Application by SP Manweb for an Order Granting
Development Consent for the Reinforcement to the
North Shropshire Electricity Distribution Network

Issue Specific Hearing on the Applicant's
Draft Development Consent Order
(dDCO)

COMMENTS BY THE EXAMINING AUTHORITY on the DRAFT DEVELOPMENT CONSENT ORDER

- KEY**
- ORDER LIMITS
 - PROPOSED 132 kV POLE POSITIONS
 - FINAL ROUTE ALIGNMENT
 - LIMITS OF DEVIATION - 5 METRE OFFSET FROM POLE POSITION

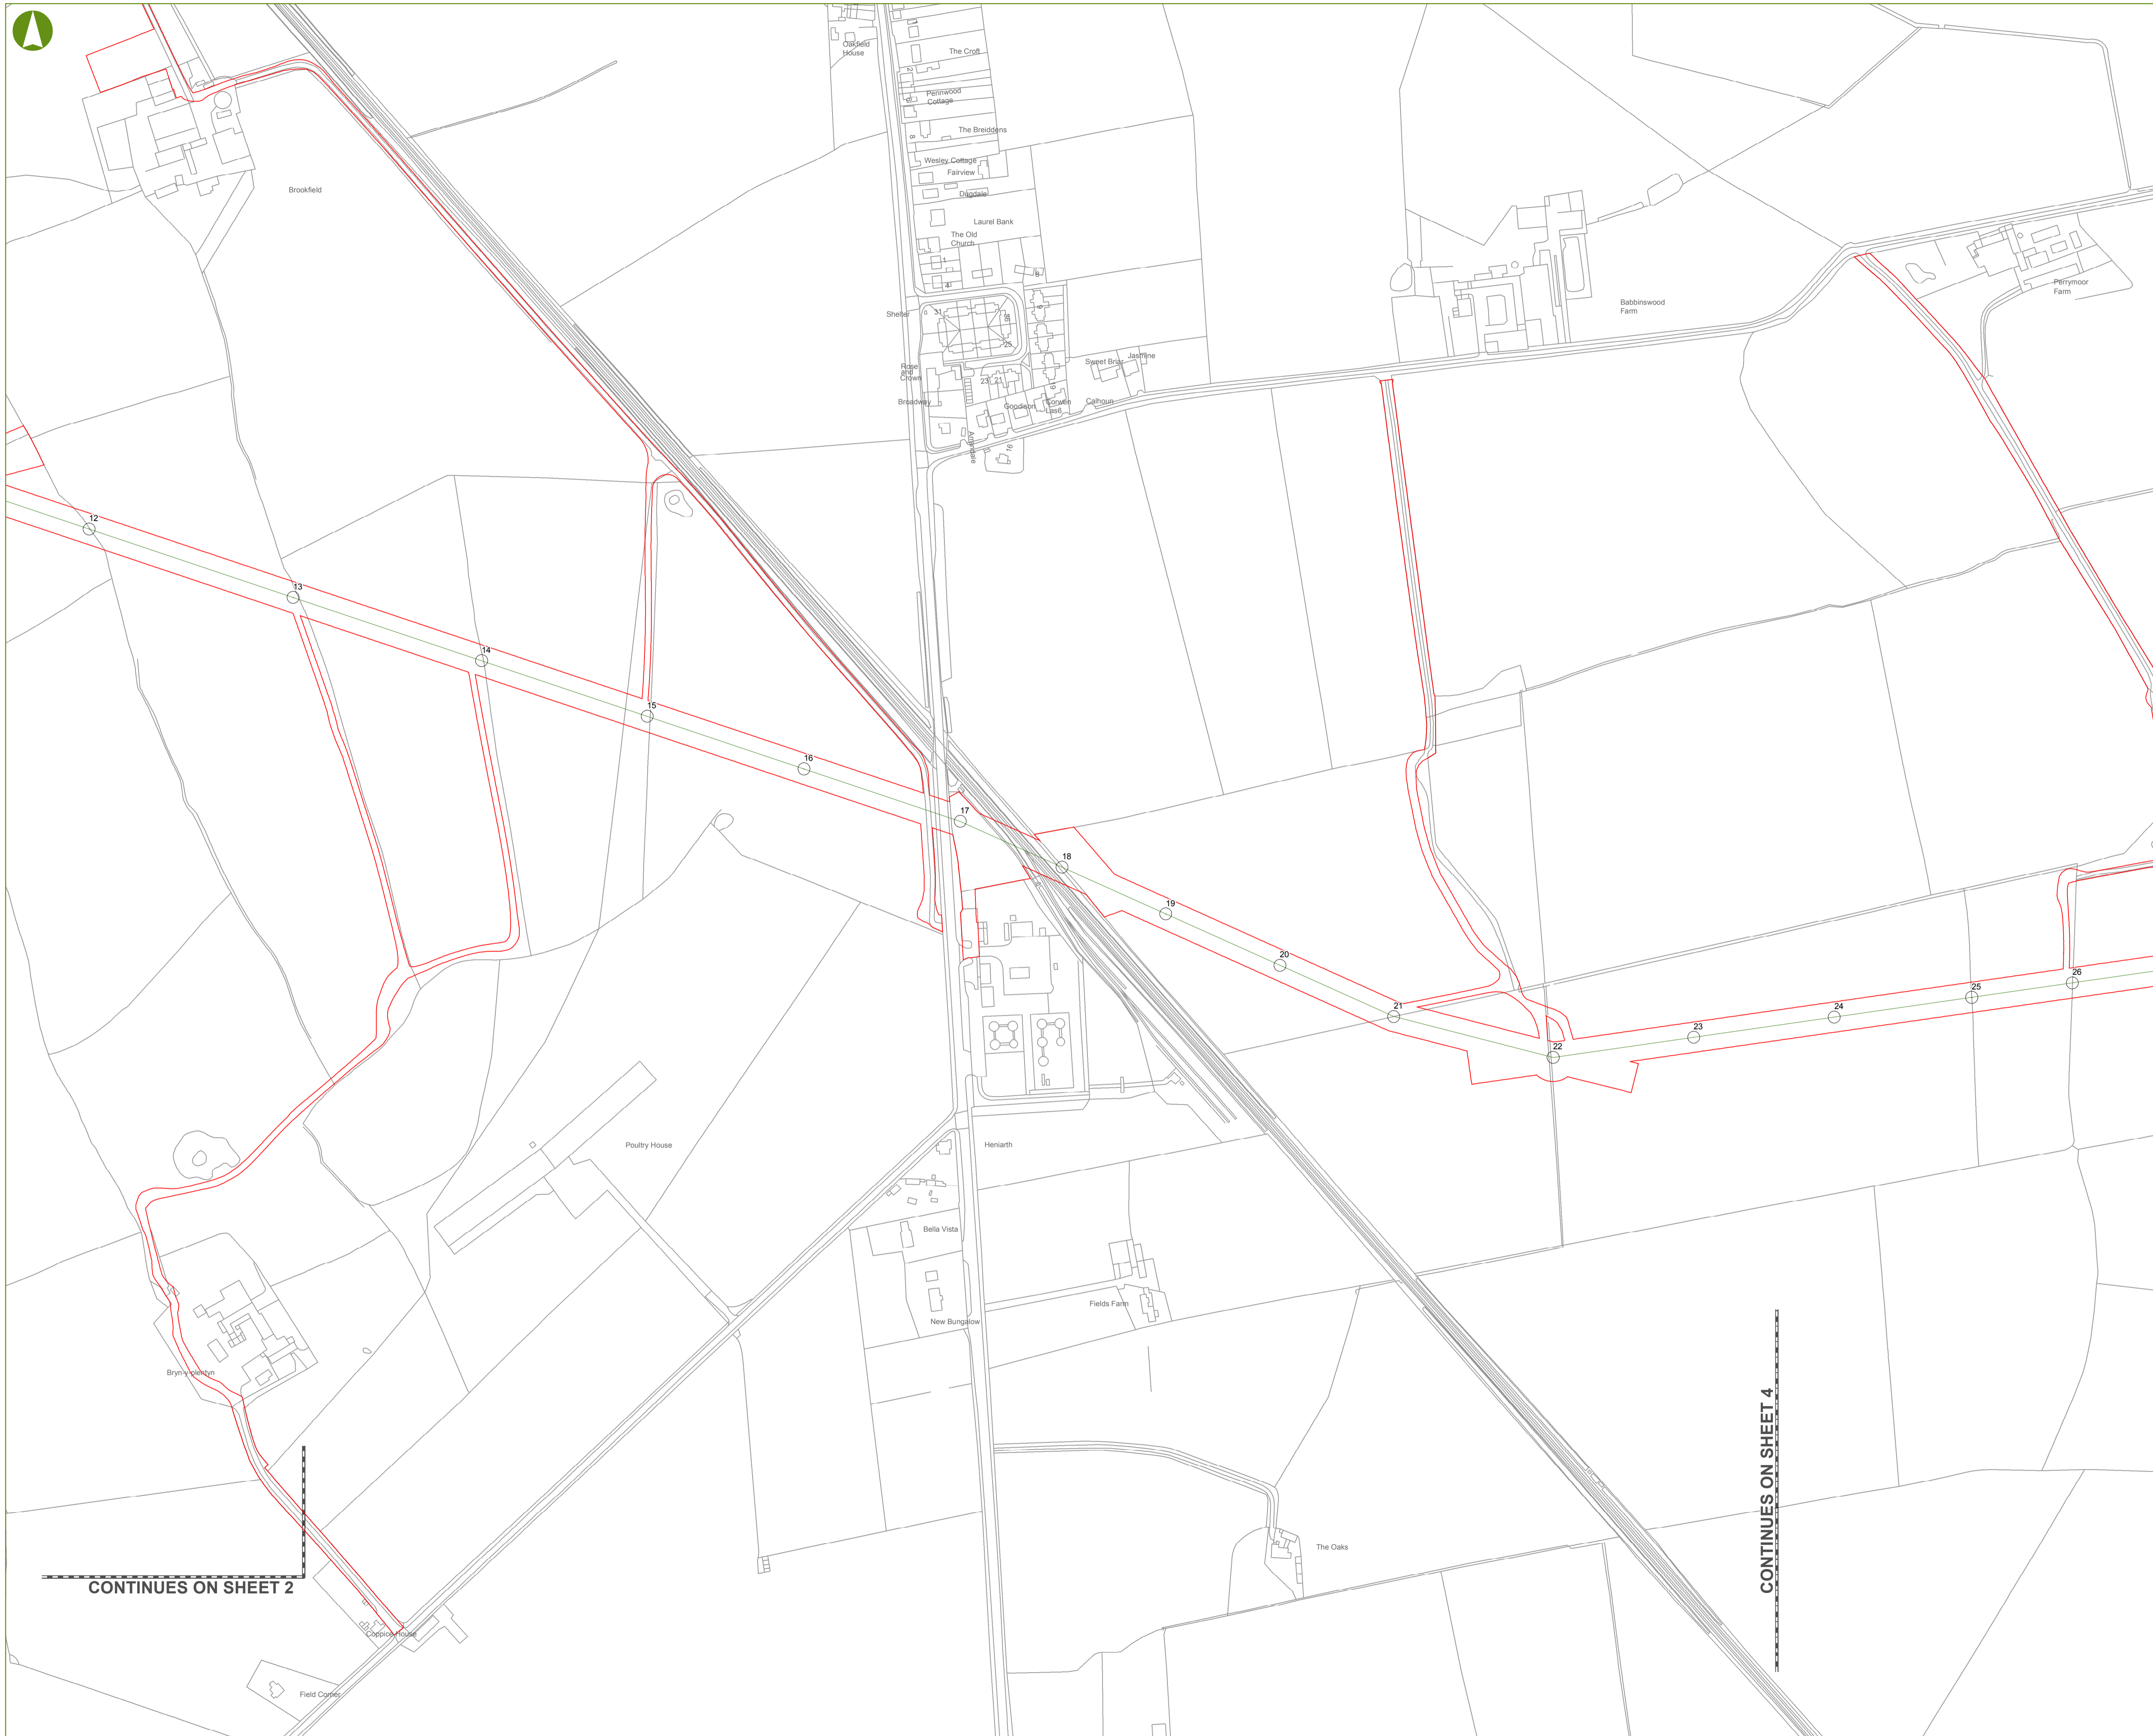
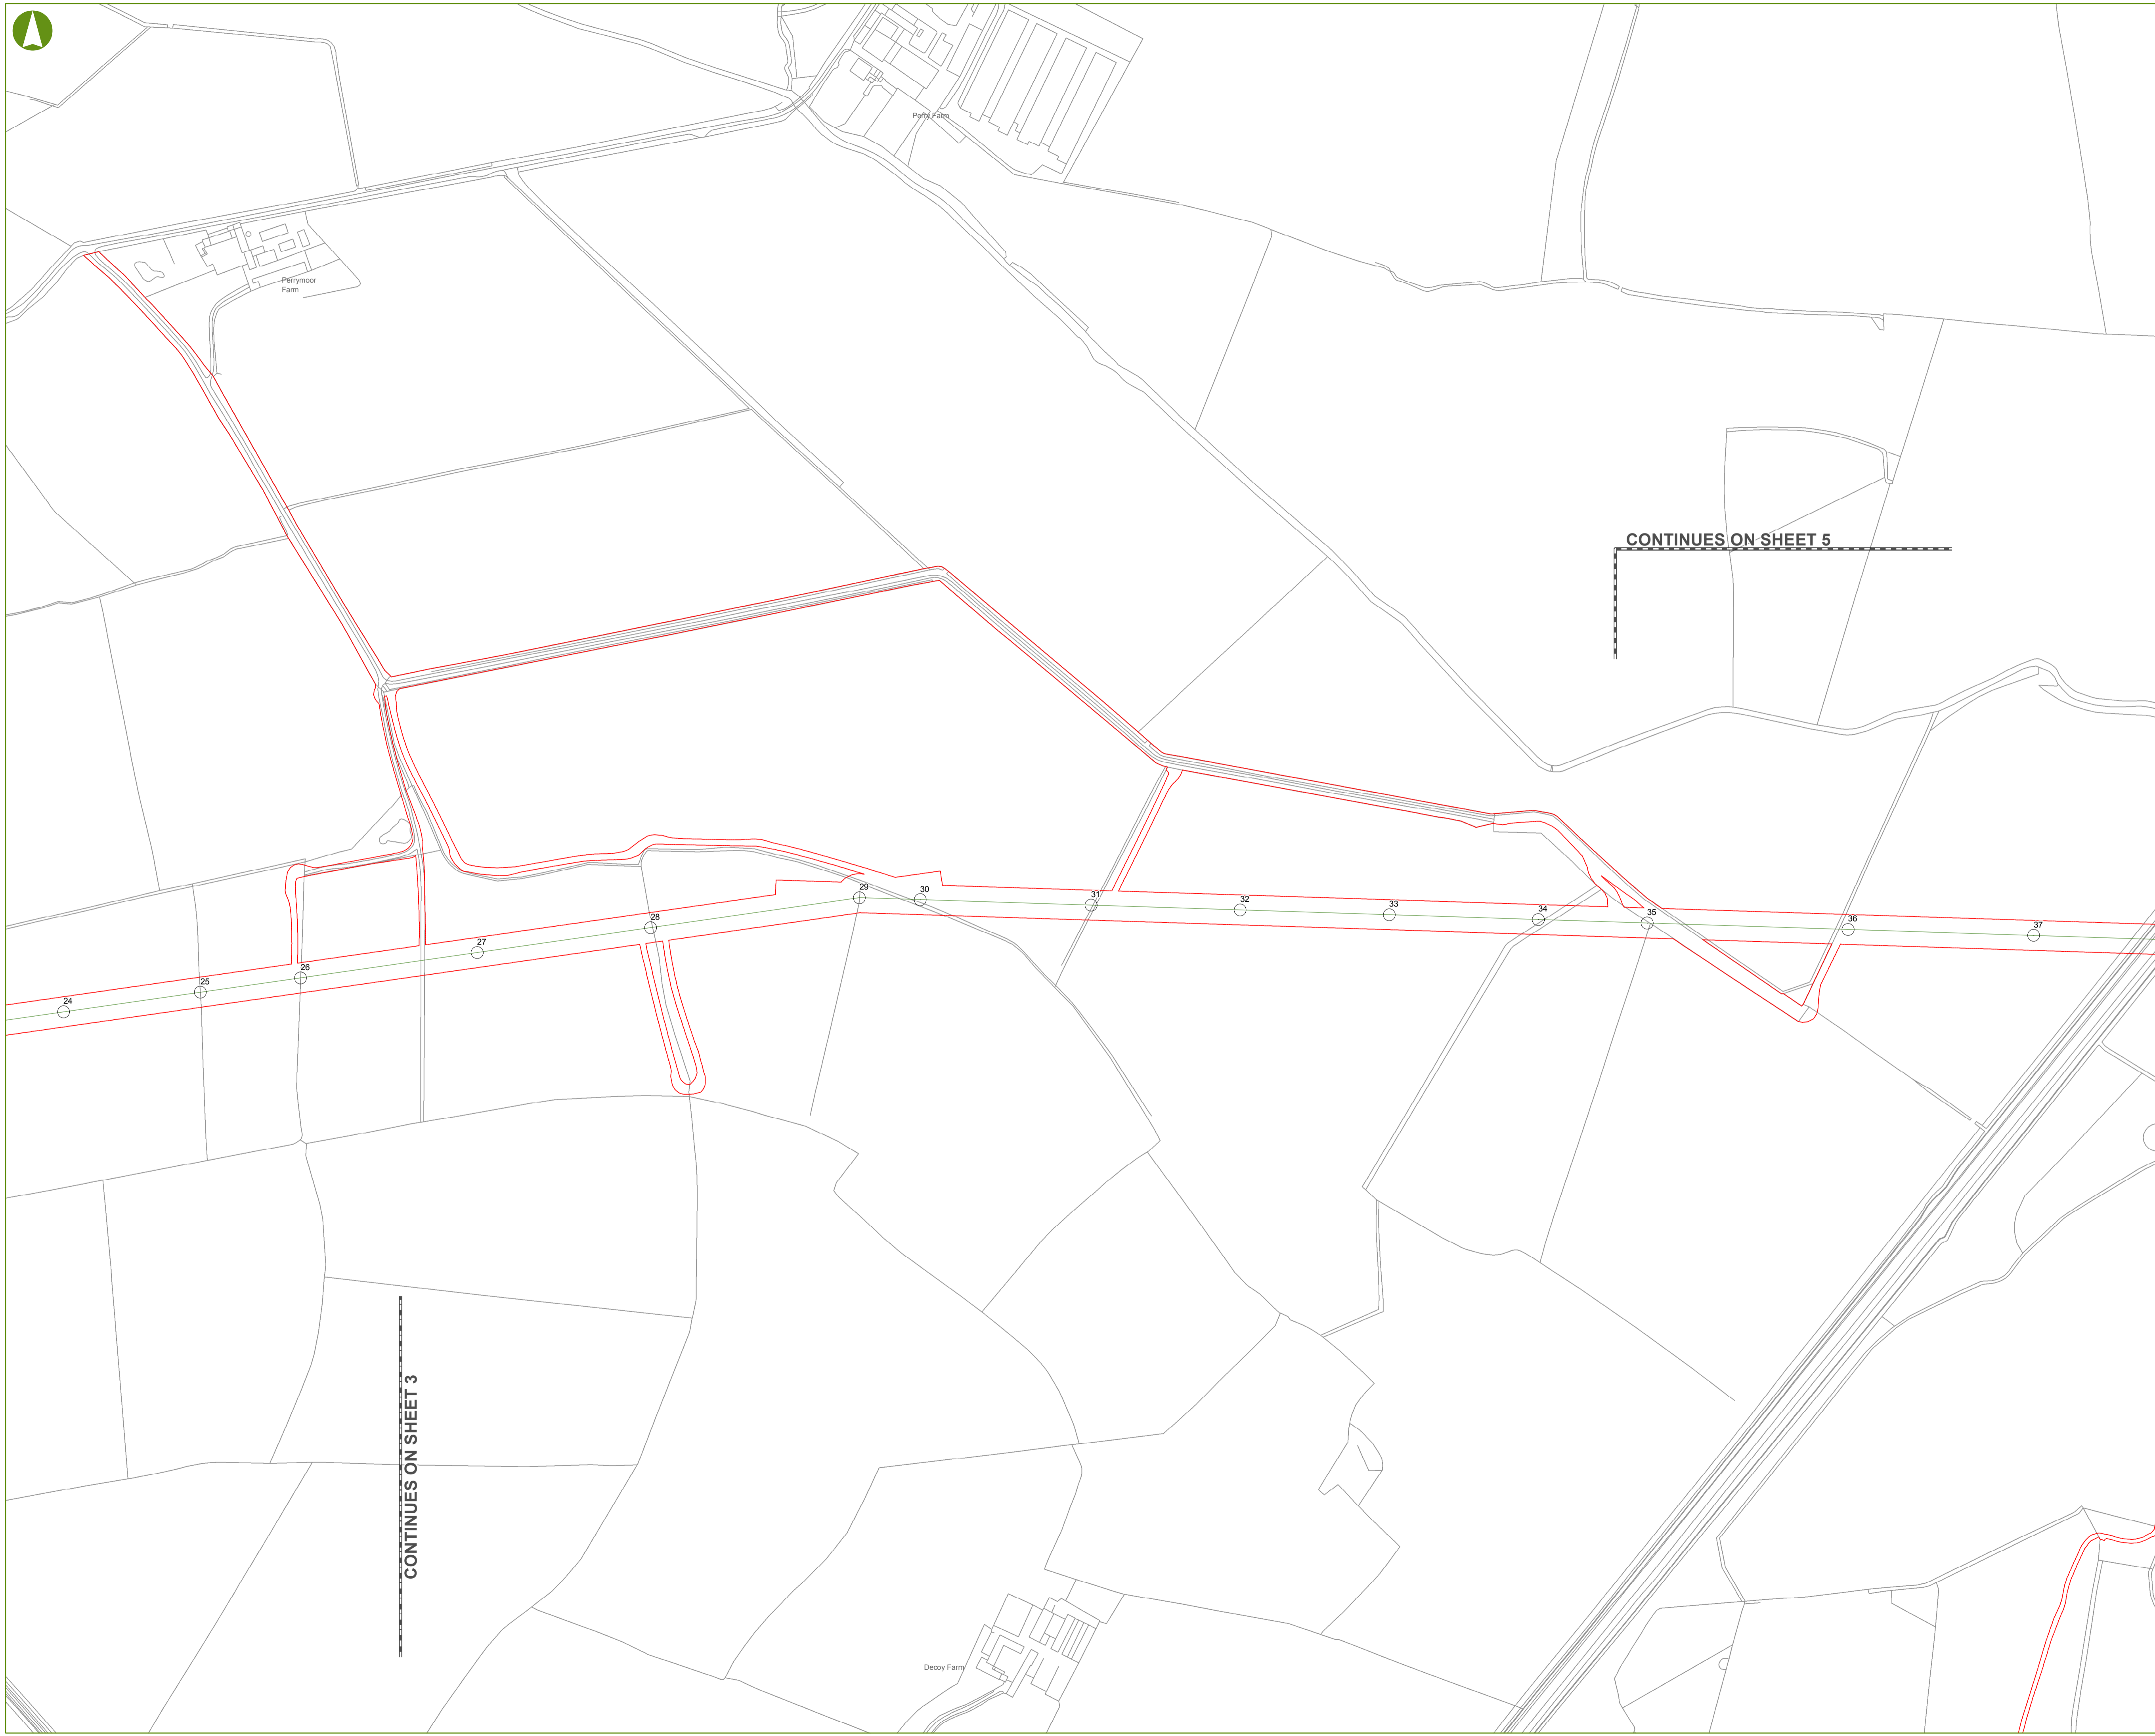
- check all documents required to be certified are included, for example Limits of Deviation Plans (AS-003) and Construction Access Location Plan (REP1-005).
